From: Anita Gardner
Sent: 20 September 2013 09:15
To: 'Phil Brown'
Subject: RE: LU/297/13/L Restoration of East elevation of building

I note that the southerly portion of the 'proposed side (east) elevation' indicates 2 new windows which are different from the existing window style. I am aware that these windows were indicated on the previous approved plans, but were not included in the description. Please can you clarify whether replacement of these windows (and any other additional windows on this elevation) are intended to form part of this proposal, if they are not, they should be indicated as existing with a single horizontal glazing bar.

EXISTING AND PROPOSED PART
EAST ELEVATION

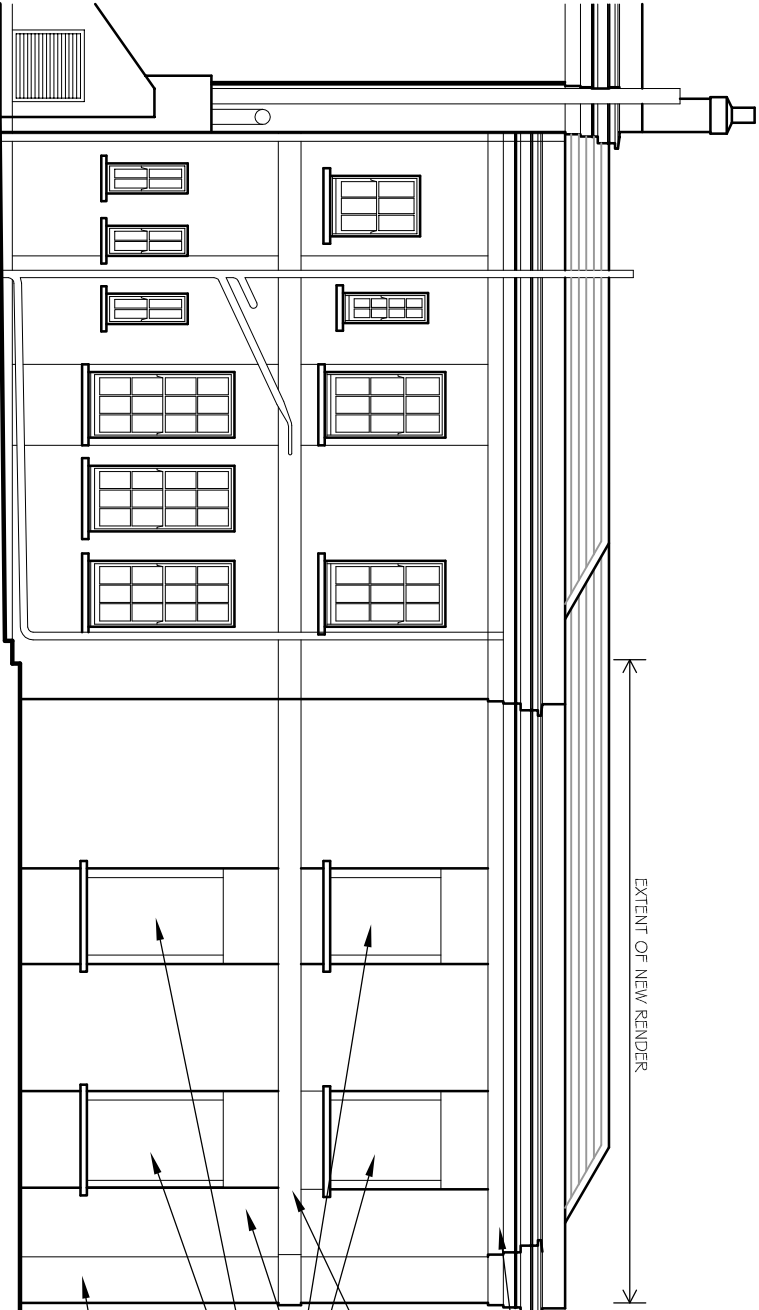
I am reluctant to add drawing 281/17 to the application as additional information since the windows on the southern end of the elevation do not accurately show the existing window style. I will therefore place a copy on file, but won't add it to the application or get it scanned to avoid confusion.

Please find attached drawing no.281/17 (1:100 at A3) which shows a greater extent of the existing and proposed east elevation. You will note this includes various existing windows, some of which were shown on the more detailed drawing previously issued. We can confirm that no new windows shall be provided as part of the proposal. We trust this satisfactorily clarifies this.
